**RE: 130 Eastern Promenade
Level 2 Site Plan Amendment
Response to Staff Review**

Project Memo: 130 Eastern Promenade

RE: Response to Staff Comments

9 TRASH ENCLOSURE
NOT TO SCALE

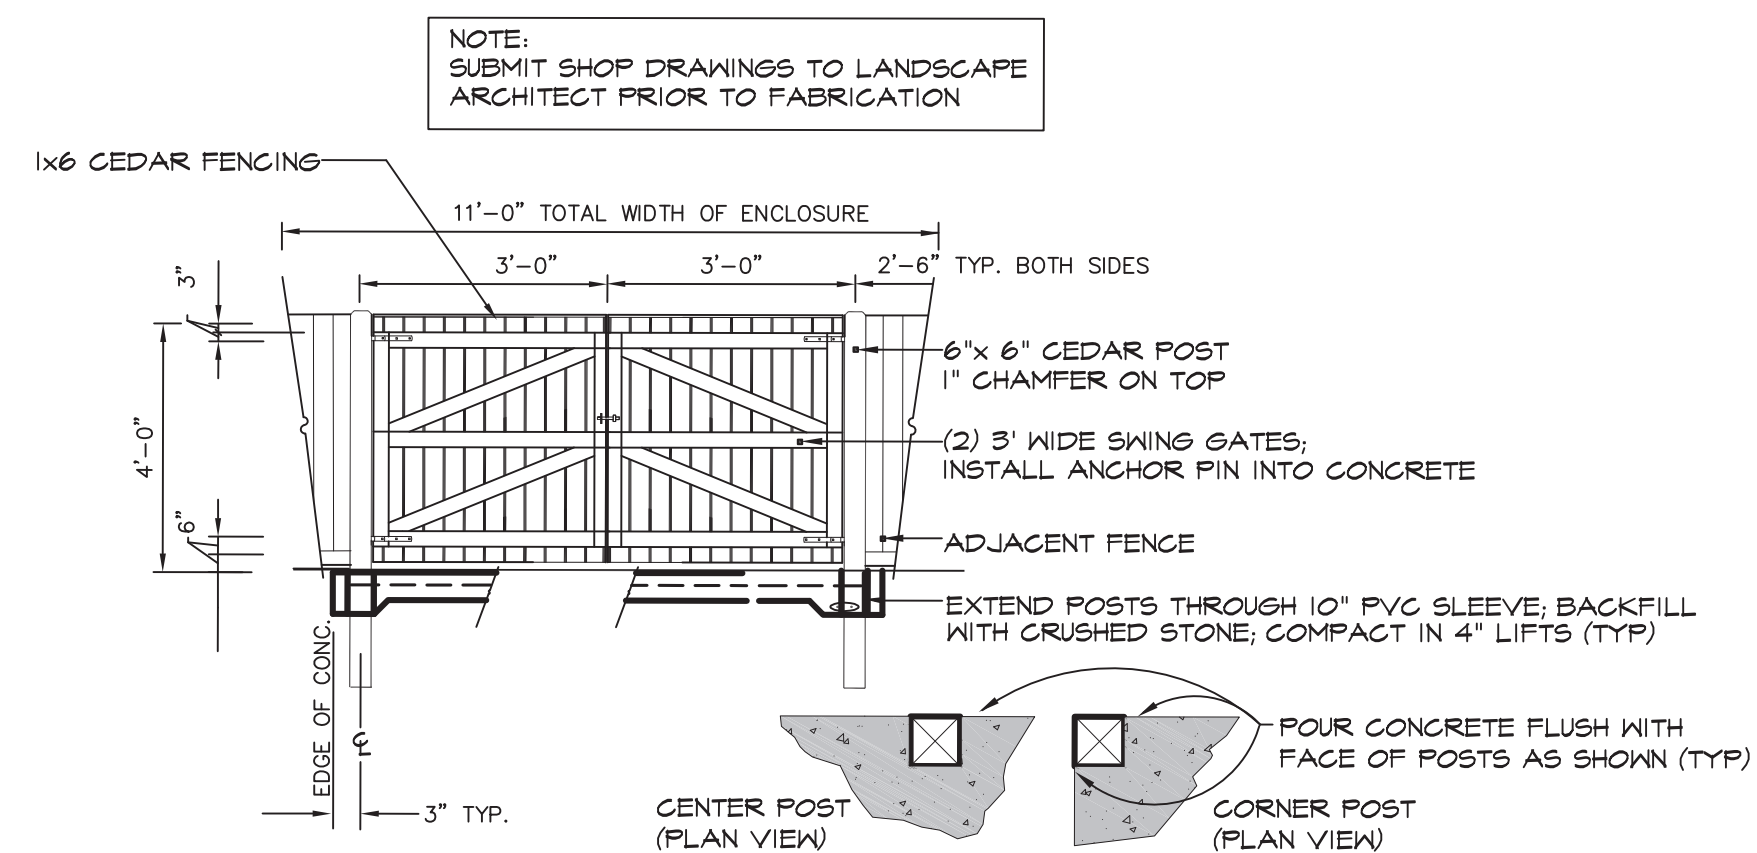
As previously noted regarding the trash area, which appears to have moved closer to the adjacent property, additional details should be provided in revised plans. These details should indicate how the proposal for the trash and recycling area has changed, how the area is now proposed to be enclosed, if at all, and proposed dimensions (including distance to the property line). Additional landscaping in this area should also be considered, in order to enhance screening.

Response: The plans have been revised to show overall dimensions of the trash enclosure, distance to the property lines, details regarding the installation, and elevations have been included for review. Additional landscaping is not possible in this area as there is no additional space to convert to planting beds.

DRAINAGE PLAN

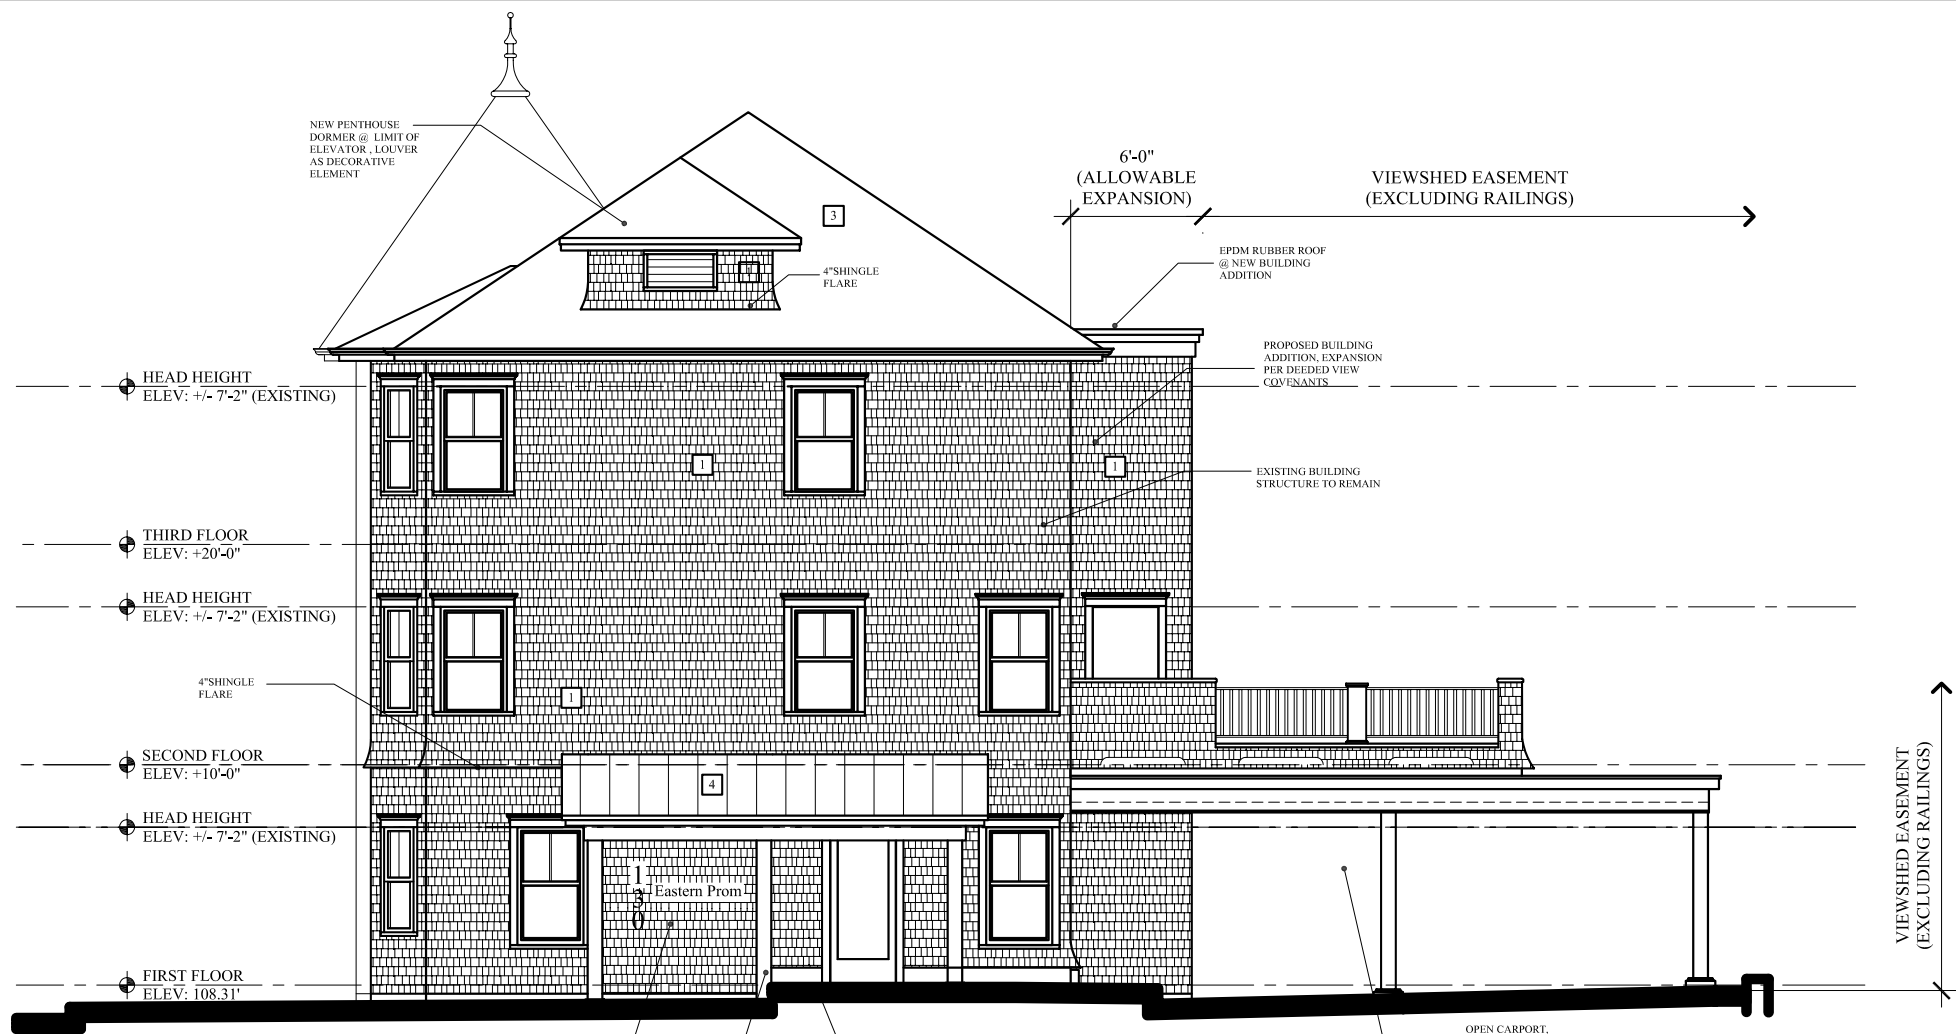
The rain garden details on sheet D-1.0 and the retaining wall detail on L-5.1 indicate that an underdrain will exist below the rain garden and at the base of the retaining wall; however, no underdrains are depicted on the site plans. If an underdrain is required for these systems, we encourage day-lighting the underdrain(s) in lieu of a direct connection to the combined sewer; clarification should be provided on the plans and/or details.

Response: The rain garden detail has been revised. The rain garden underdrain layer was replaced with 18" of crushed stone to provide water storage below the elevation of the proposed weep holes thru the existing wall. These weep holes and 12" of crushed stone behind the existing wall will provide drainage and eliminate any hydrostatic pressure behind the wall. Infiltration is not anticipated to be a problem, given that well-draining soils are common on the peninsula.

**Typical Window & Door Head Elevation Detail
N.T.S.**

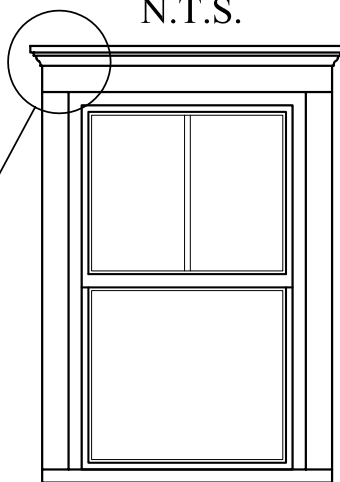
As the project lies adjacent to the Eastern Promenade Historic Landscape District, Deb Andrews, Historic Preservation Manager, has reviewed the revised elevations. She has suggested that the architect consider retaining more of the building's original details, as shown on the 1924 tax photo (and which appear to be omitted in the amended plans), such as the window lintel detail, the first floor entry details, and the dentil course on the pediment. Direct discussion with Ms. Andrews on this matter is suggested. She can be reached at 874-8726.

The revised window head lintels are detailed on the drawings. A lintel trim profile has been included in the project.
